SUBJECT: Y/5/17/OUT-Outline application for 51no. dwellings with all matters reserved except for access. This application is a Departure from the Development Plan.

Cinders Nursery & Land R/O, Cinders Lane, Yapton, West Sussex, BN18 0JJ

RECOMMENDATION: OBJECTION/MORE INFORMATION

CONCEPTUAL LAYOUT

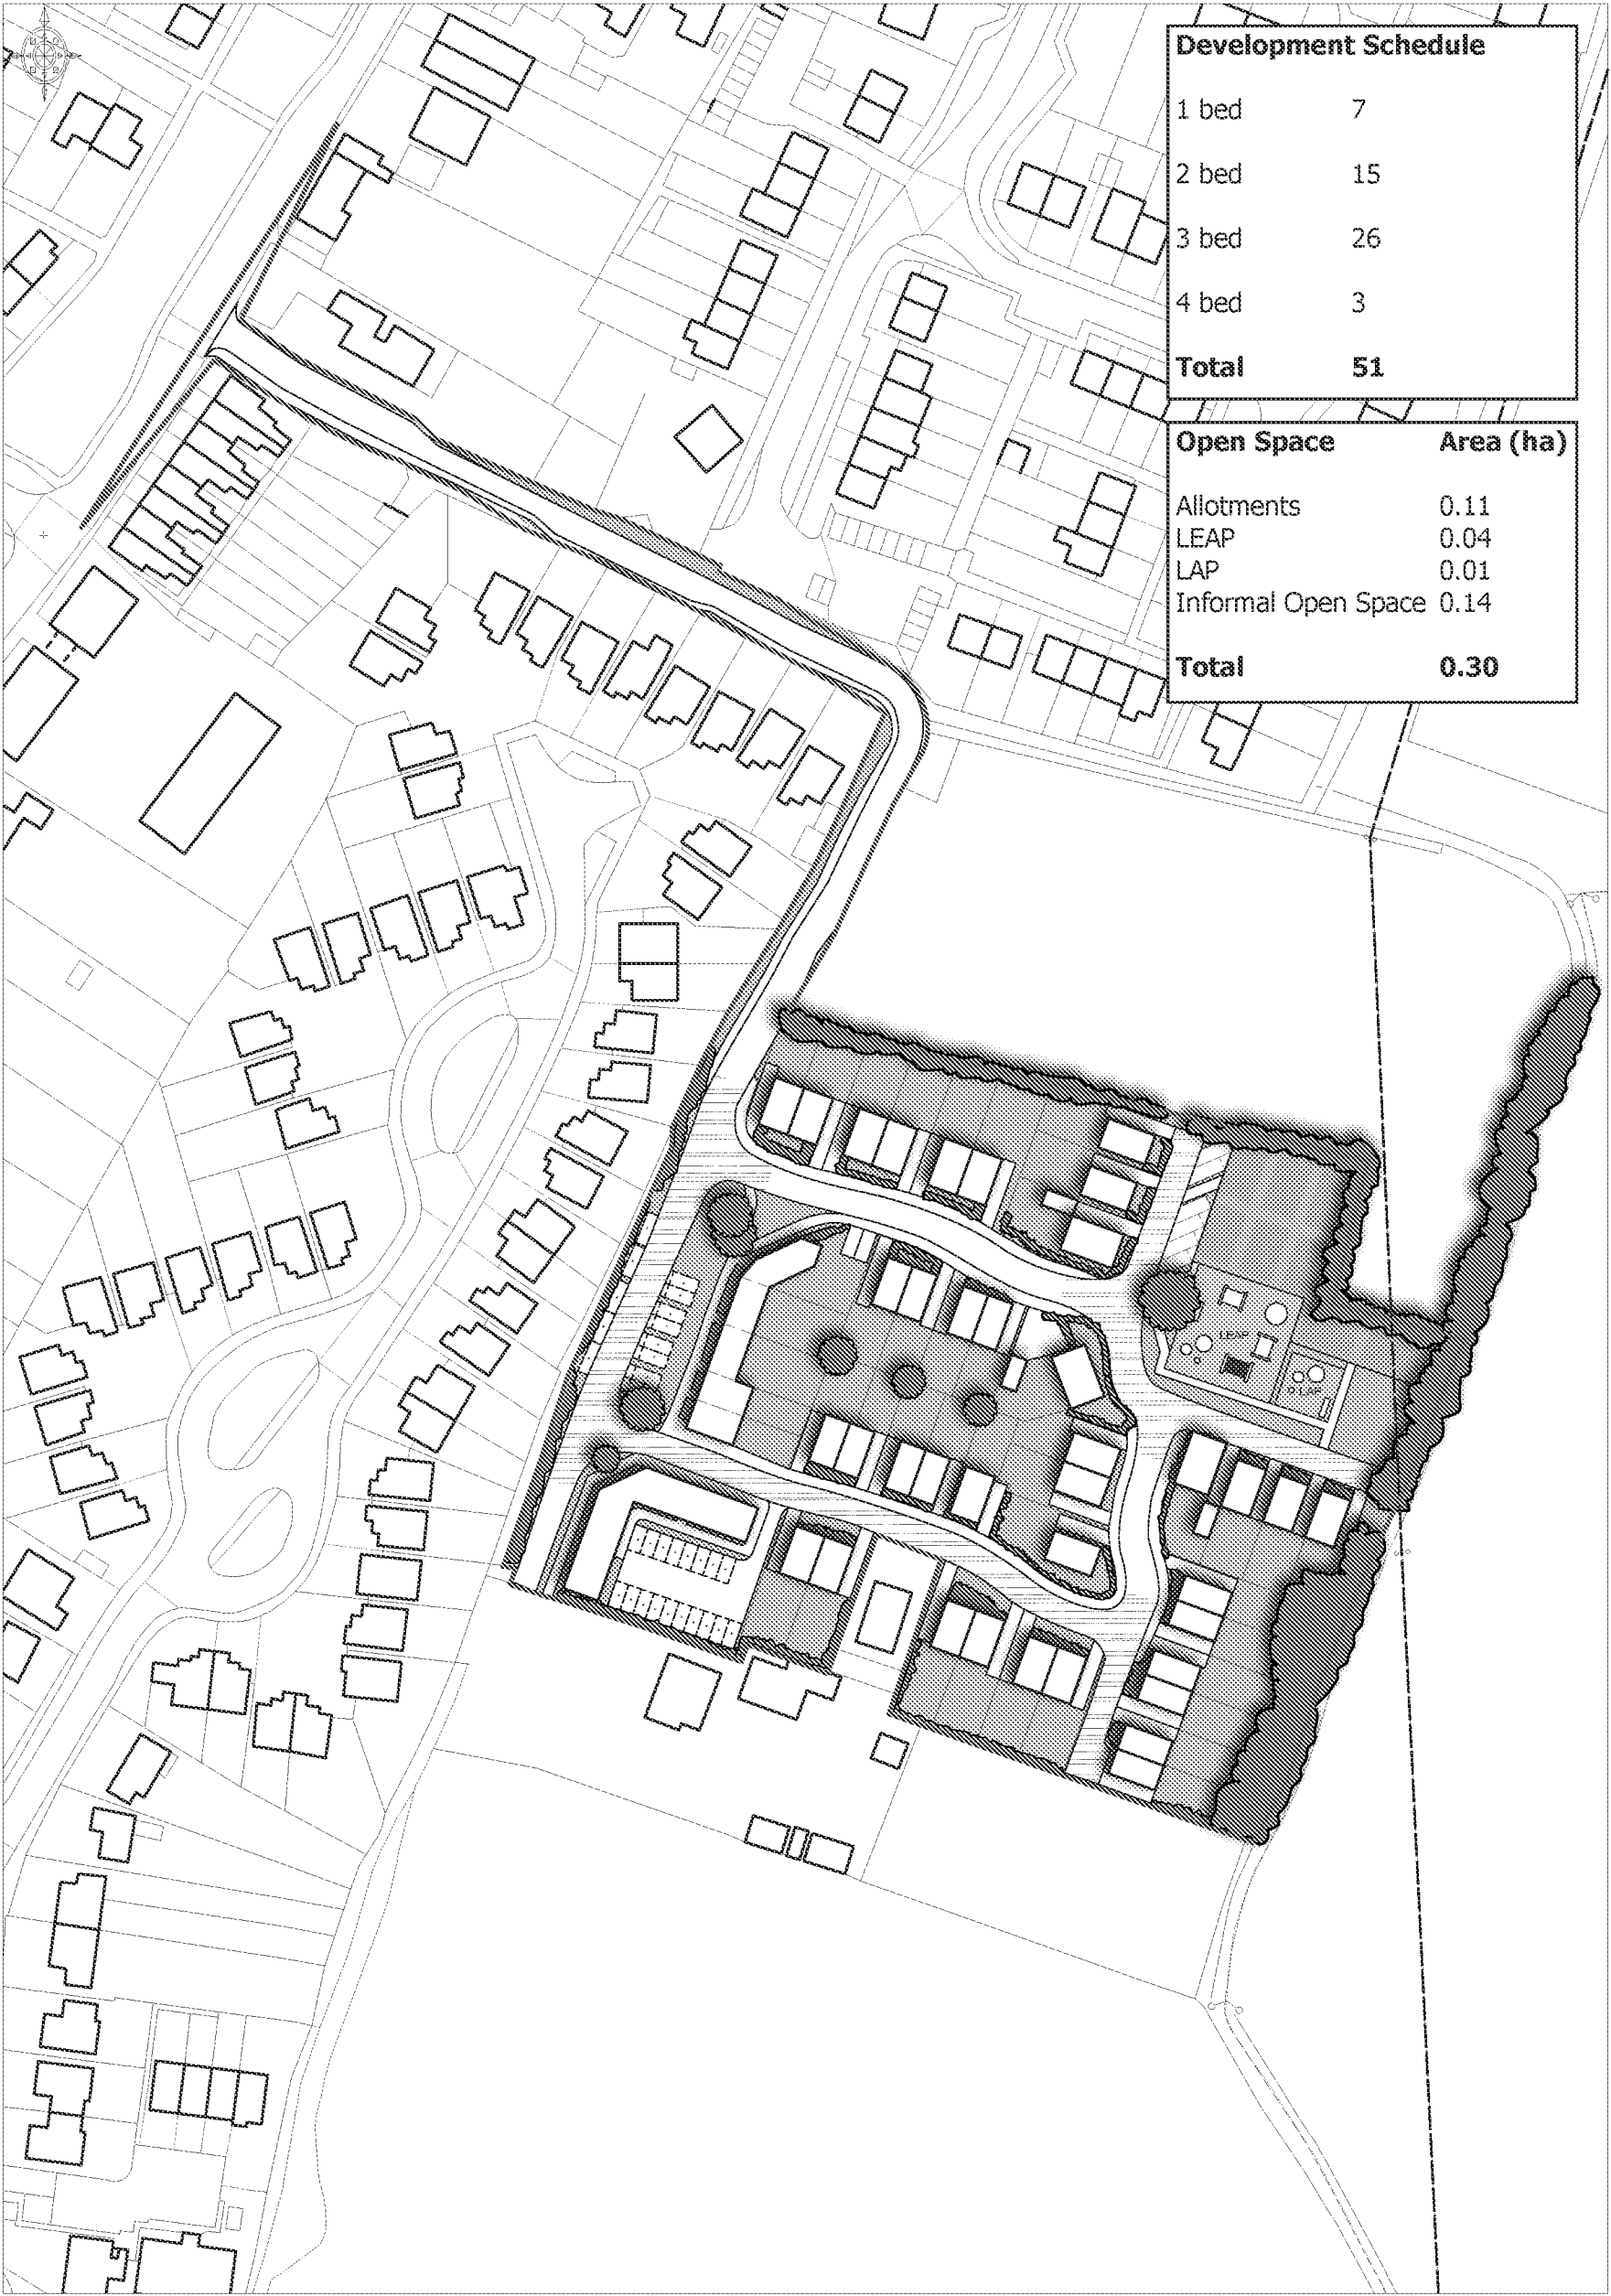
The internal arrangements including the road widening were agreed in principle with WSCC at the pre-application stage. Whilst it is acknowledged that permission for the sites layout is not sought, there are no initial concerns with the indicative layout, designed in accordance with Manual for Streets (MfS) parameters. The application will include the widening of Cinders Lane and the provision of footways for pedestrians. The proposal includes a new access and widening of Cinders Lane to accommodate the additional movements. The access road will initially be widened to 5.5 metres enabling two vehicles to pass one another. A footway will also be provided at a minimum of 1.2 metres in width. Advisory signage is to be provided to inform the direction of priority for site users.

Refuse collection will take place from within the site. It has been stated that swept path diagrams will be provided showing larger vehicles turning paths within the site. The applicant should liaise with ADC's Waste Collection Team to discuss the suitability of this arrangement.

It has not been stated if the revised access road will be constructed to adoptable standards. Given comment in the TS, it would appear that the Lane will remain in private ownership. Should the Applicant wish to offer the internal layout for adoption, an adoptable layout plan would be required at the layout reserved matter stage alongside a Design Audit of the internal layout.

Appendix D

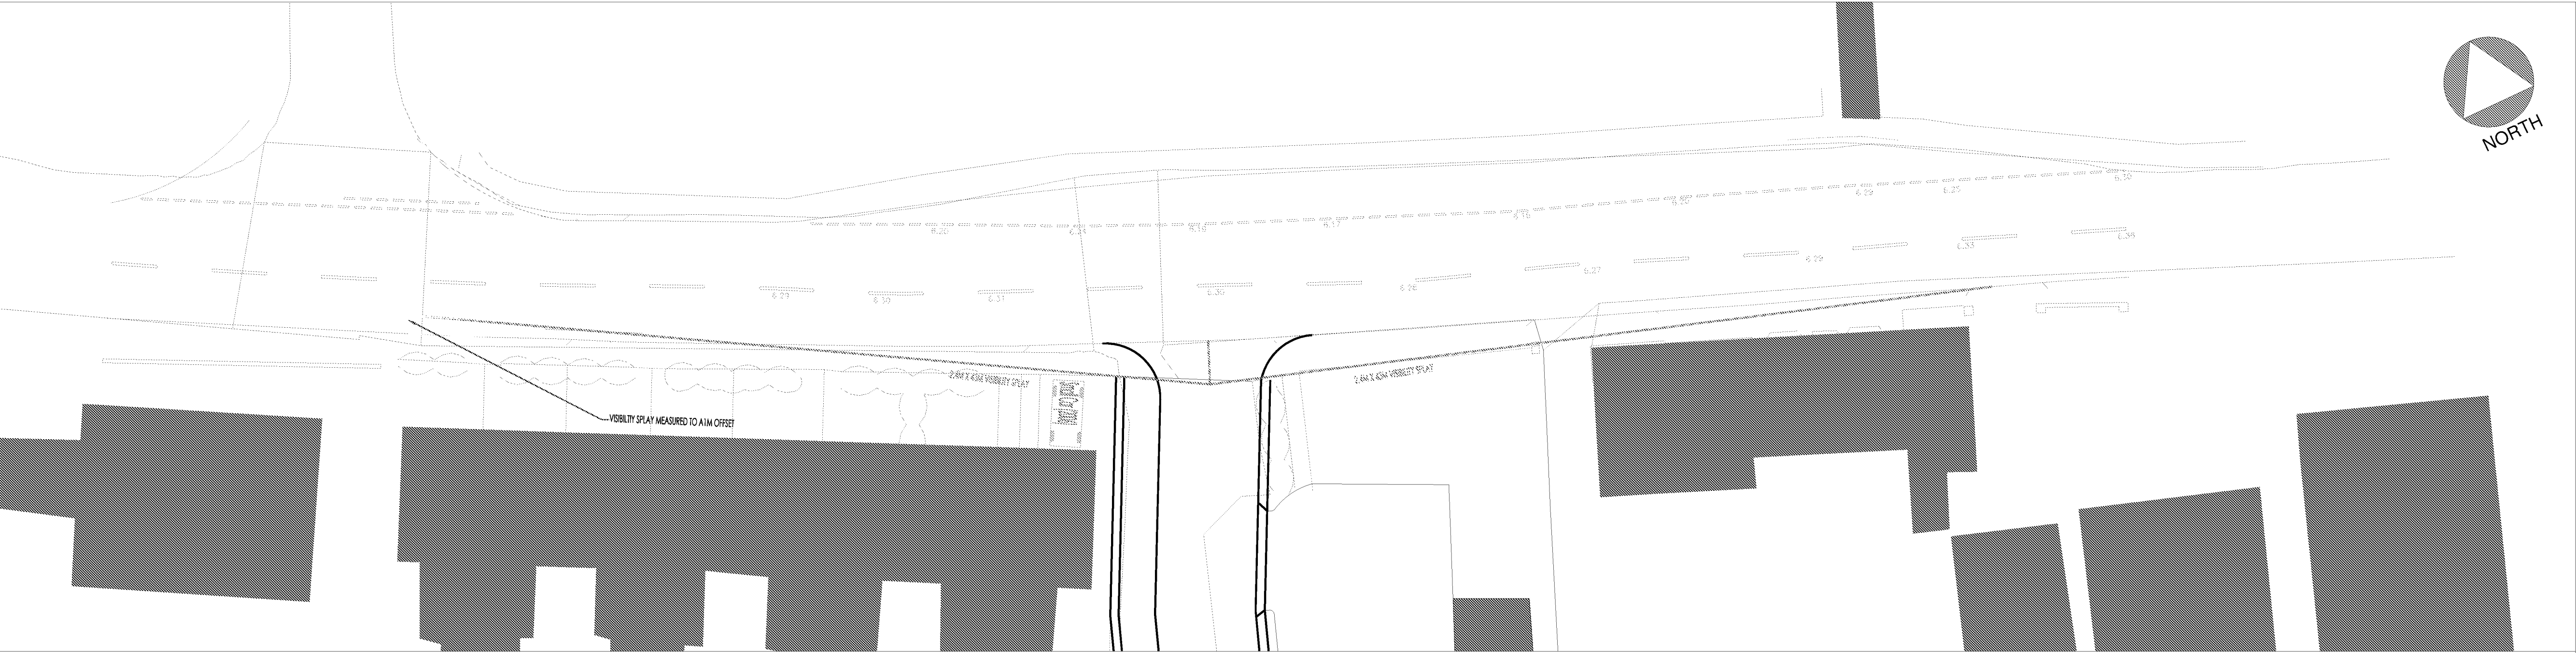
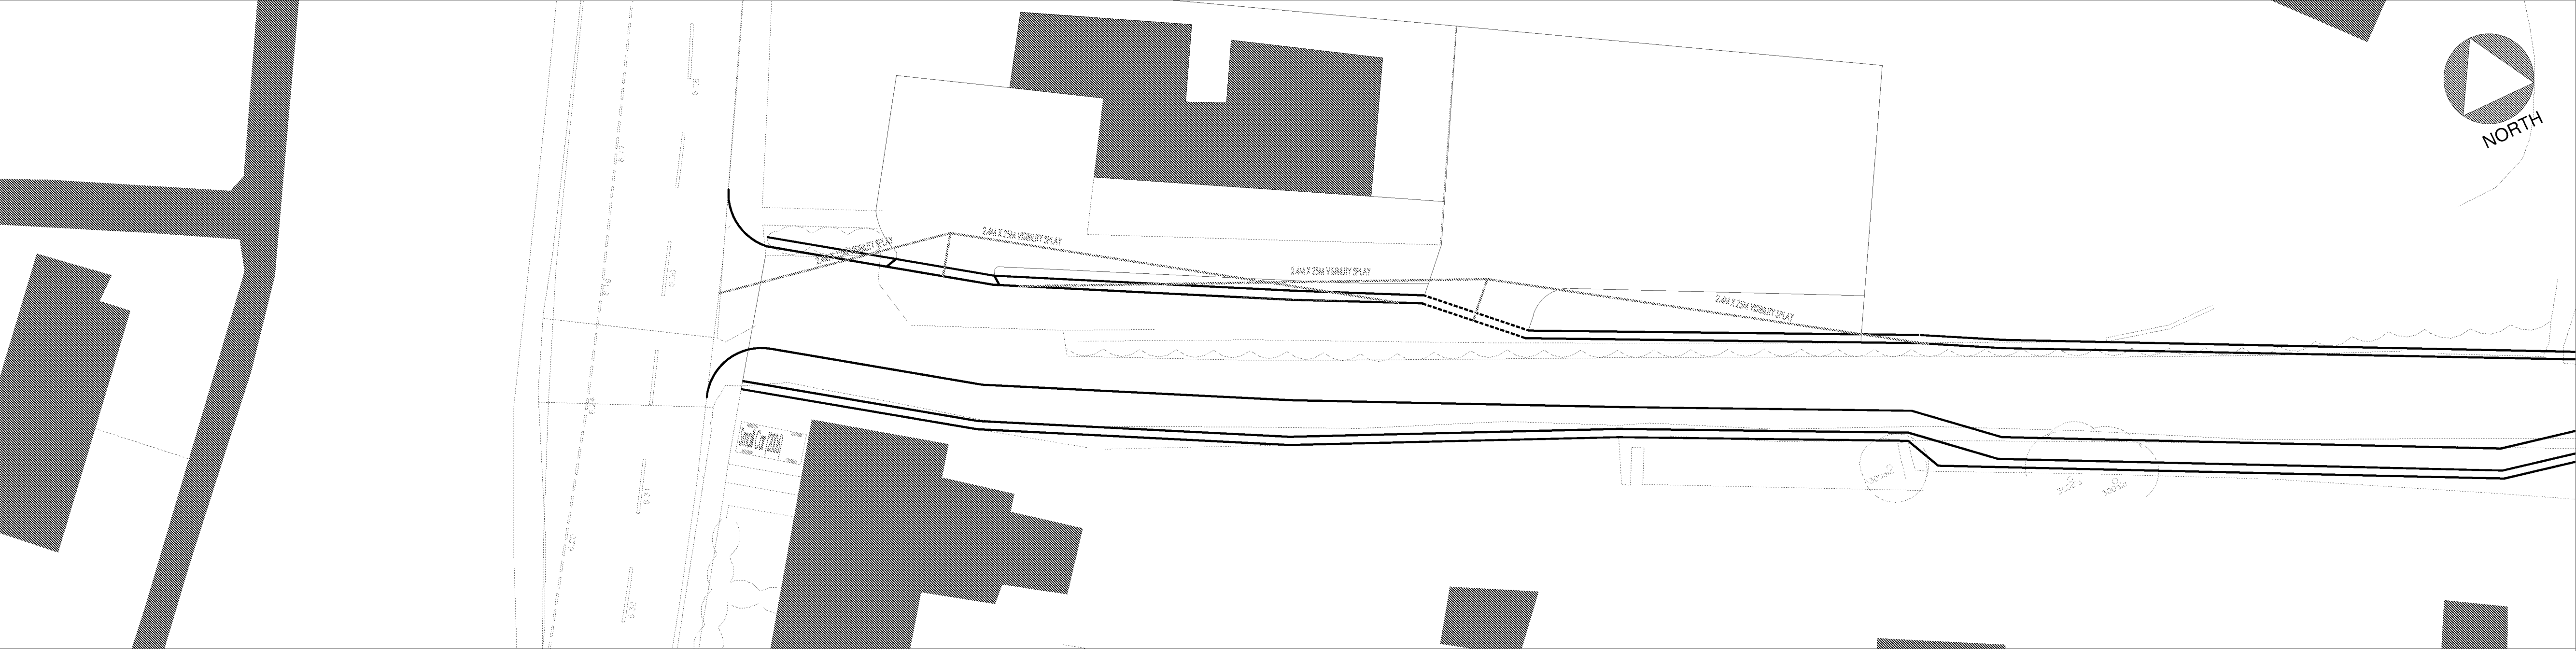
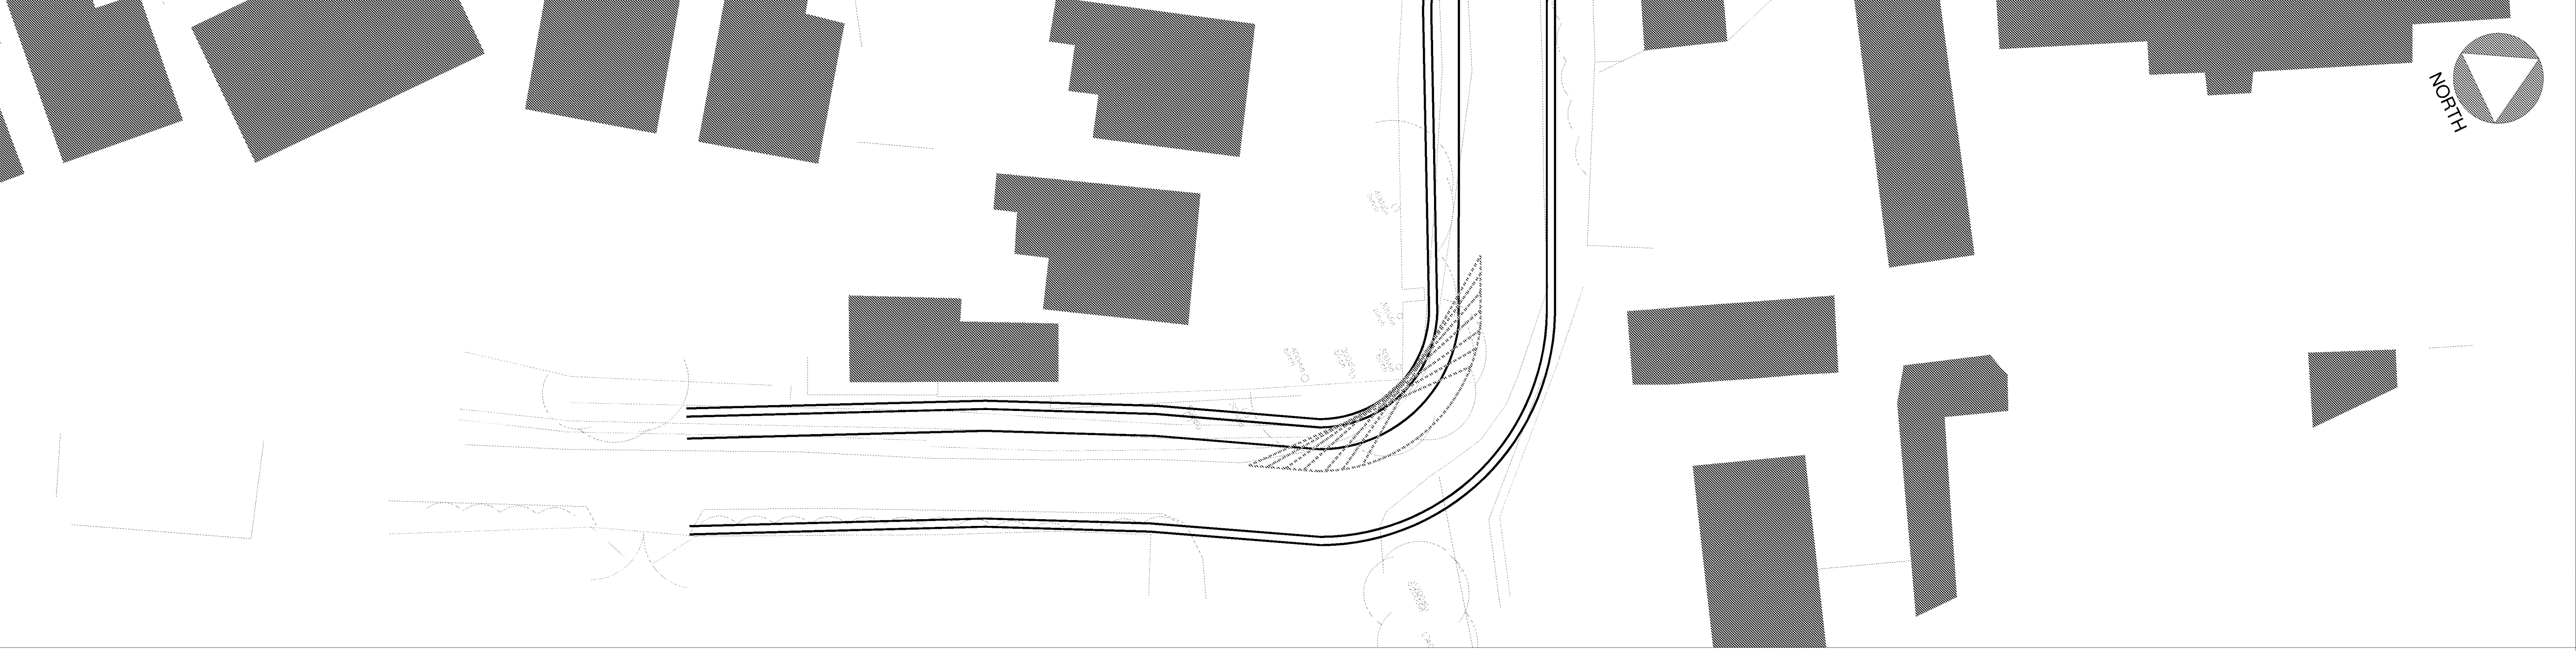
The existing access will be widened to accommodate the proposals, further comments on the acceptability of the access modifications will be provided once the RSA has been submitted. The doctors surgery immediately to the north of the site is severed from the same access, the proposals include a re-design to the access for the surgery. In accordance with the speed limit of 30 mph visibility splays of 2.4 by 43 metres can be achieved in both directions from the existing junction onto the B2132. Finally, tracking for larger vehicles should be provided, demonstrating they can successfully negotiate the access safely.
